Response to Planning application from Hertfordshire County Council (T and CP GDP Order 2015)

District ref: 6/2021/1649/VAR
HCC ref: WH/7396/2021
HCC received: 1 June 2021
Area manager: Matthew Armstrong
Case officer: Samuel Tearle

36 THE RIDGEWAY CUFFLEY POTTERS BAR EN6 4AX

Variation of condition 10 (Site Vehicular Areas) and 20 (Approved Drawings), on planning permission 6/2018/2863/FULL

<b>PLANNING</b>				
	Client	CAVENDO HOMES			
Job Title	CUFFLEY	Date	01.21	Scale	NTS
Chandos House Back Street Wendover Bucks HP22 6EB tel: 01296 625995 fax: 01296 622617 e-mail: info@hfparchitects.co.uk	Drawing Title	COMPARISON SITE PLANS		Job no	3356
		Drawing No	PD111	Rev.

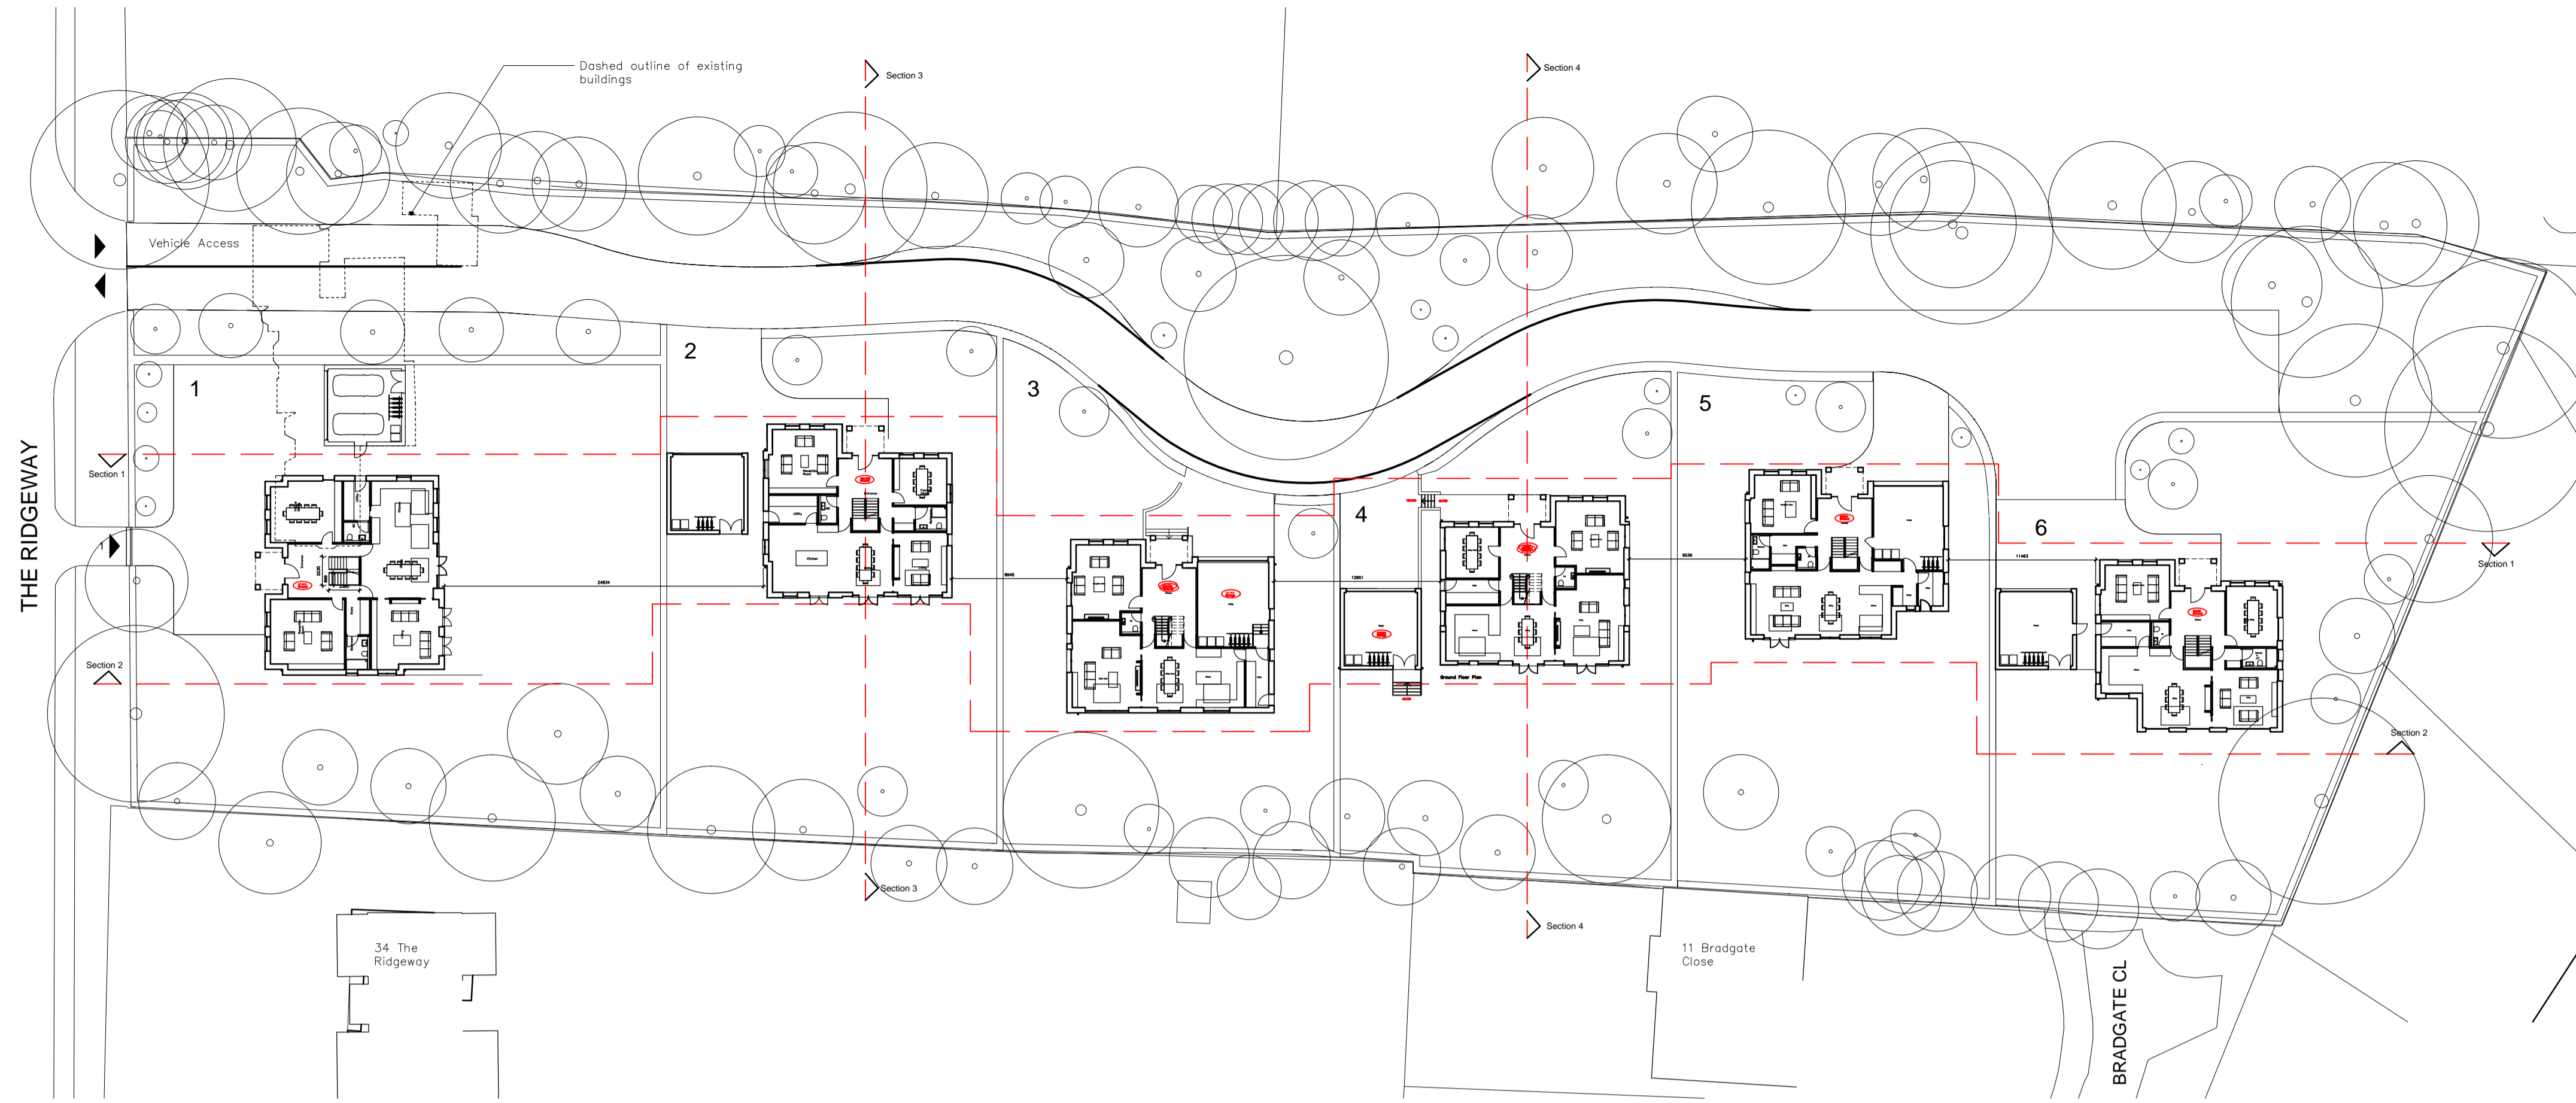
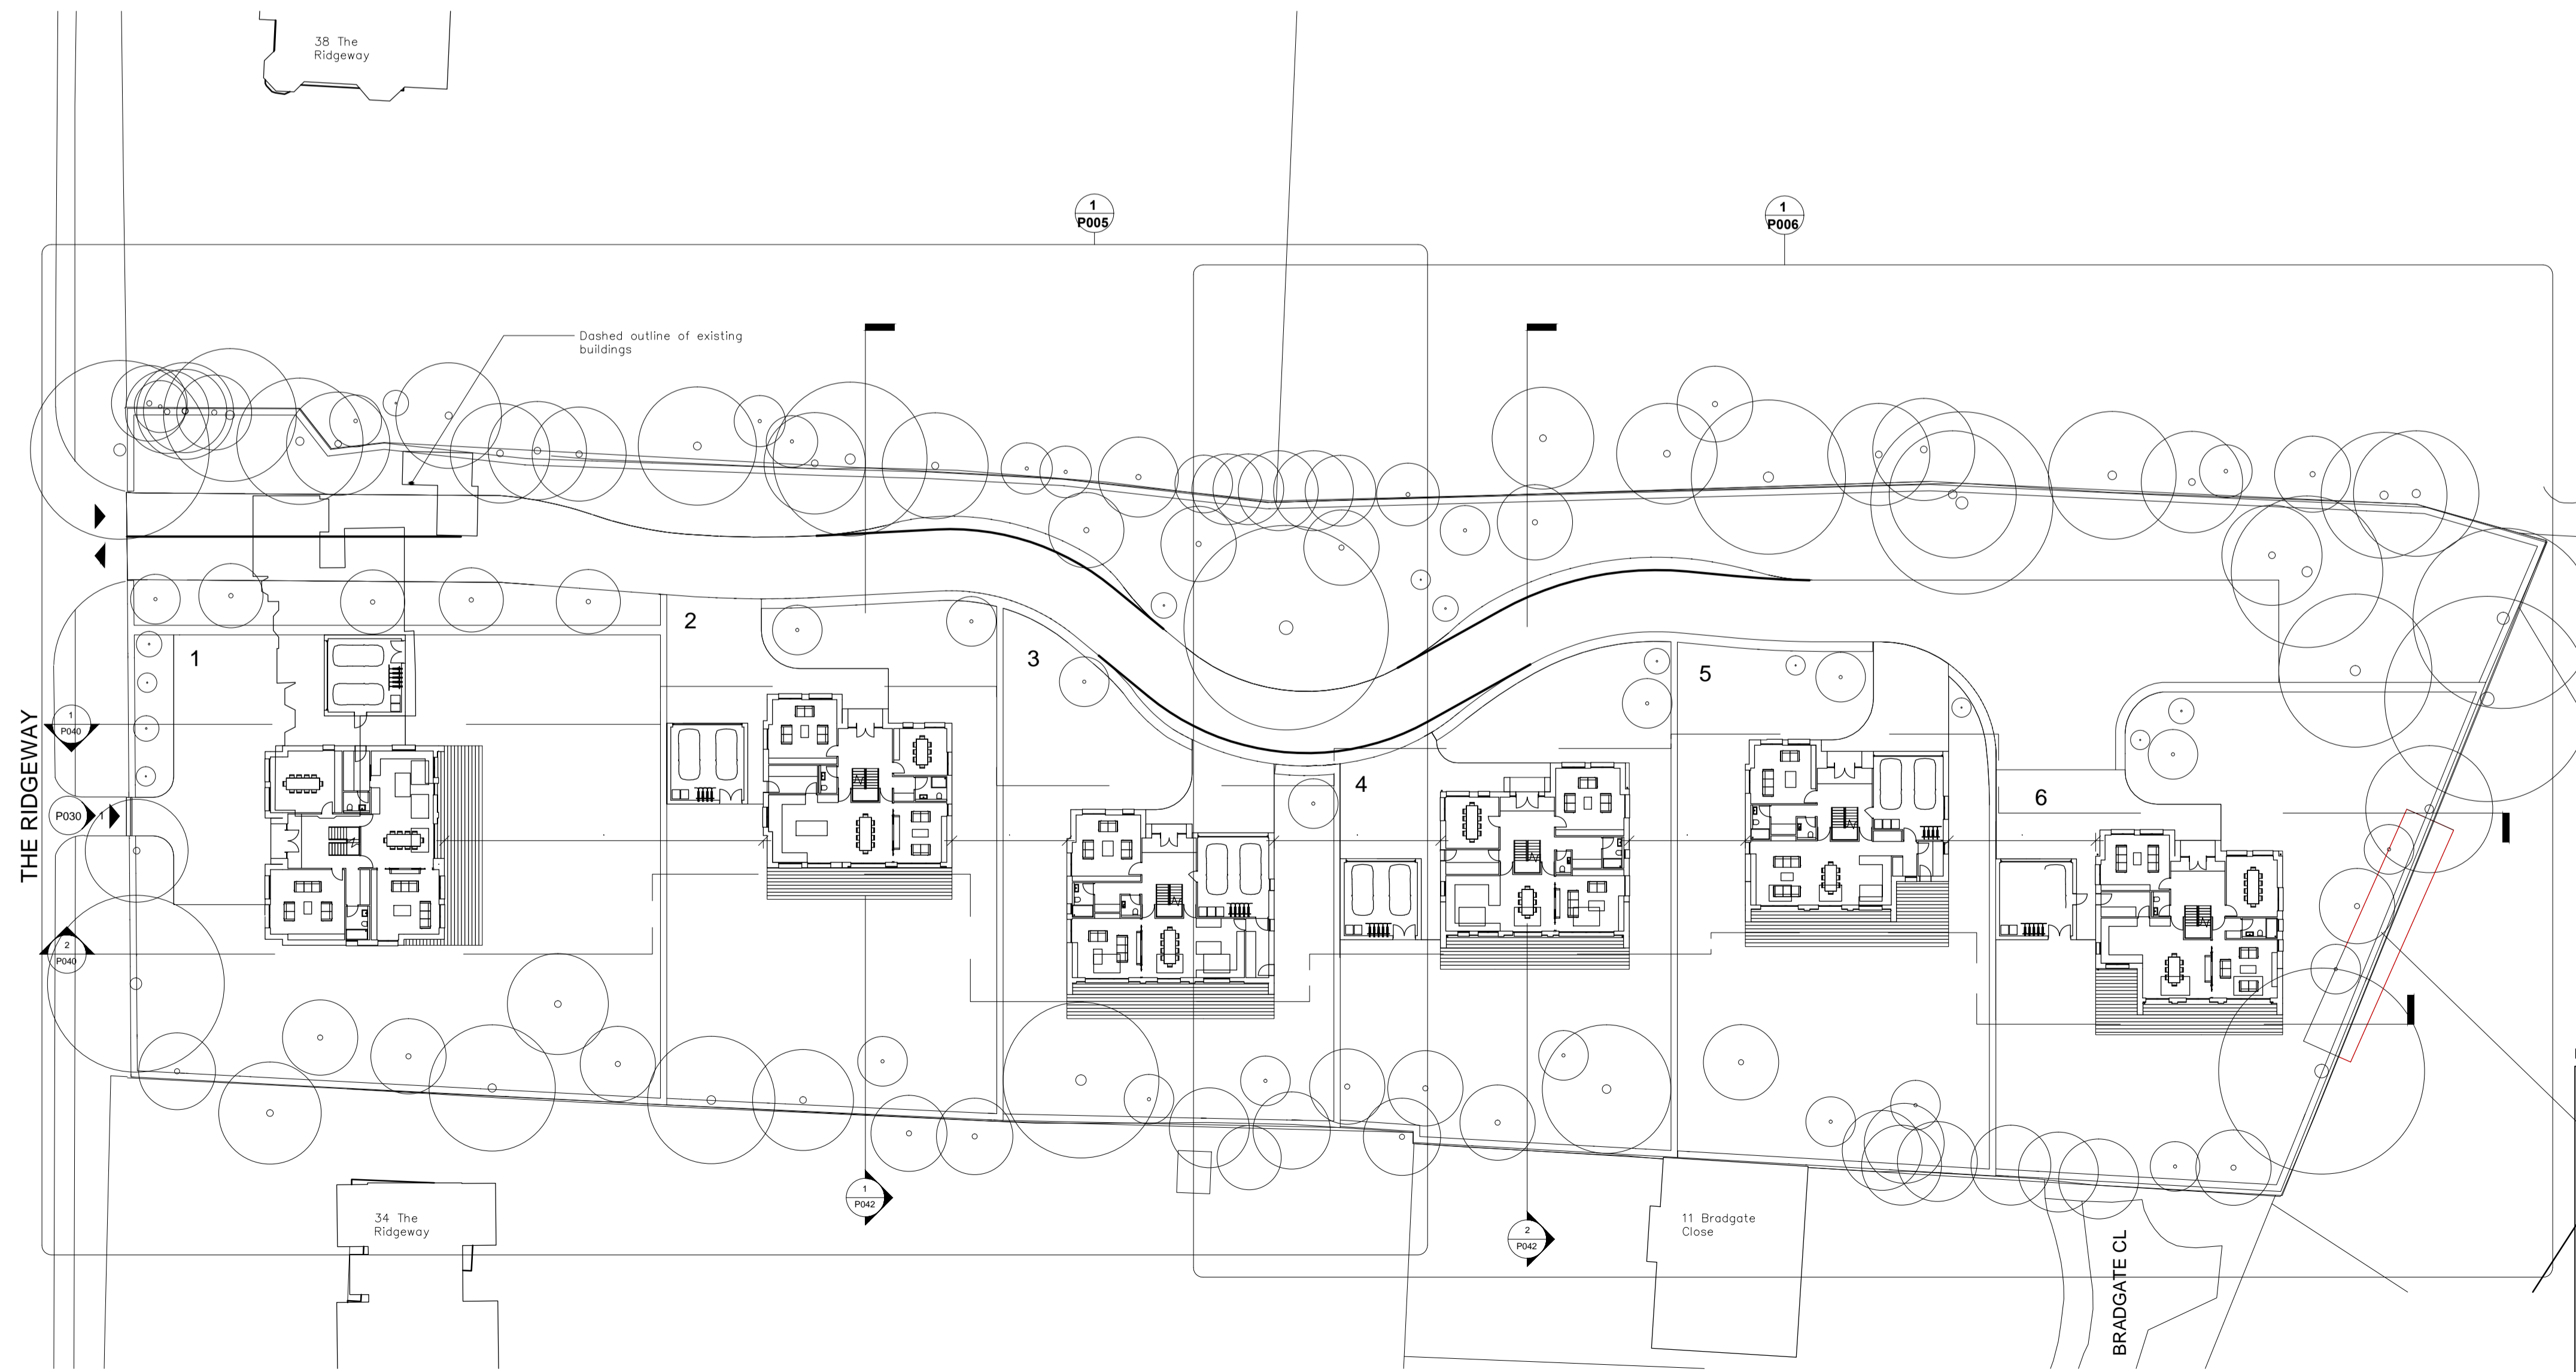
The Highway Authority have reviewed the changes to the Elevations and Internal arrangements, alongside the Comparison of Site Plans (Drawing No PD111). The Highway Authority are satisfied the proposed variations would not result in a severe impact to the operation or safety of the local highway and footway networks and therefore does not wish to raise an objection to the variation of Condition 20.
